Re: Portland Retirement Residence

These are responses to your email comments/redlines dated May 25, 2016

Reviewer – Laurie Leader
Phone 207-874-8714/ email – irl@portlandmaine.gov

FIRE SPRINKLERS

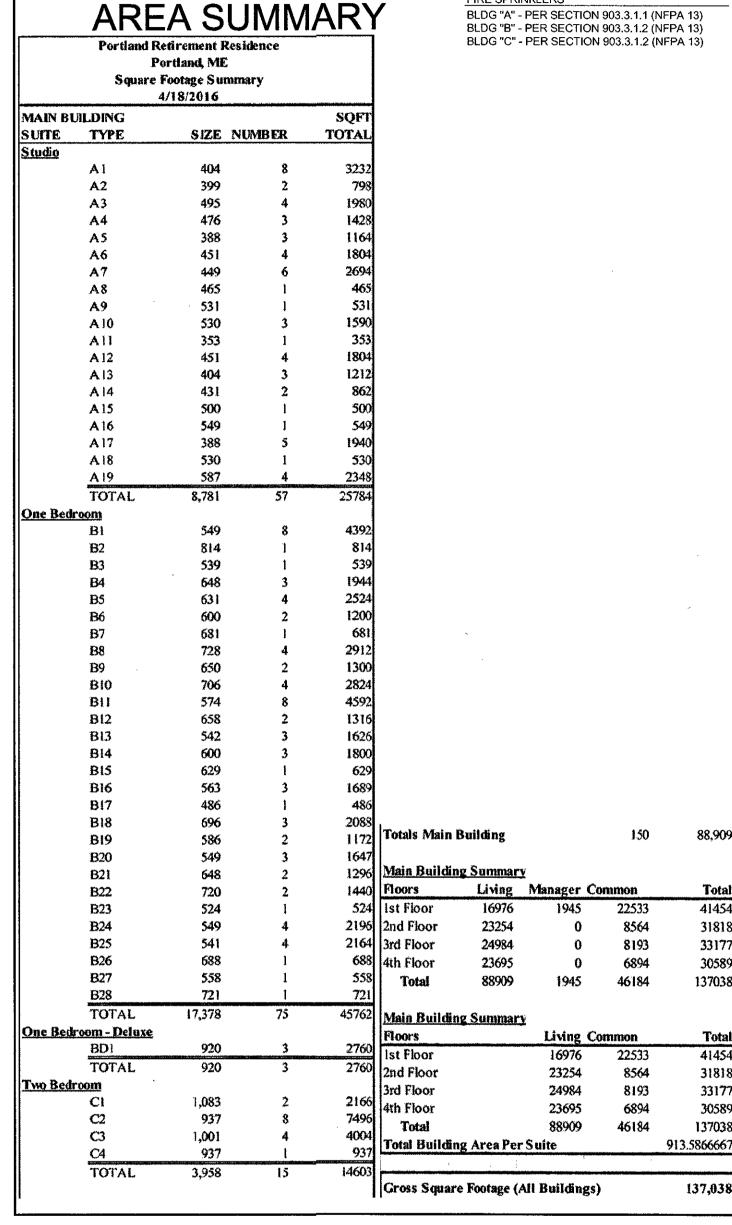
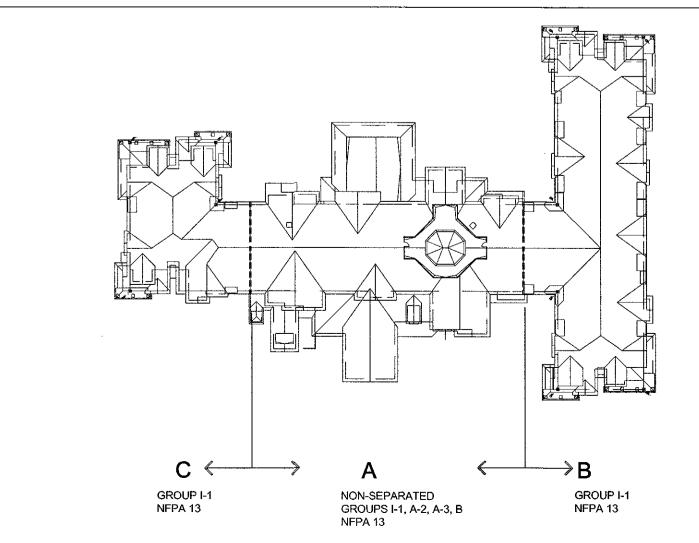
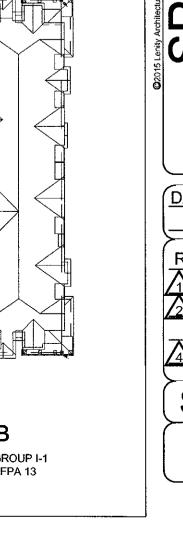
Sheet [M5.3](#) – see redlines

3. The code analysis says the sprinkler system is an NFPA 13 not 13R. Please clarify and revise.

Please see updated note on sheet M5.3 indicating the use of NFPA 13 sprinkler system, not NFPA 13R.
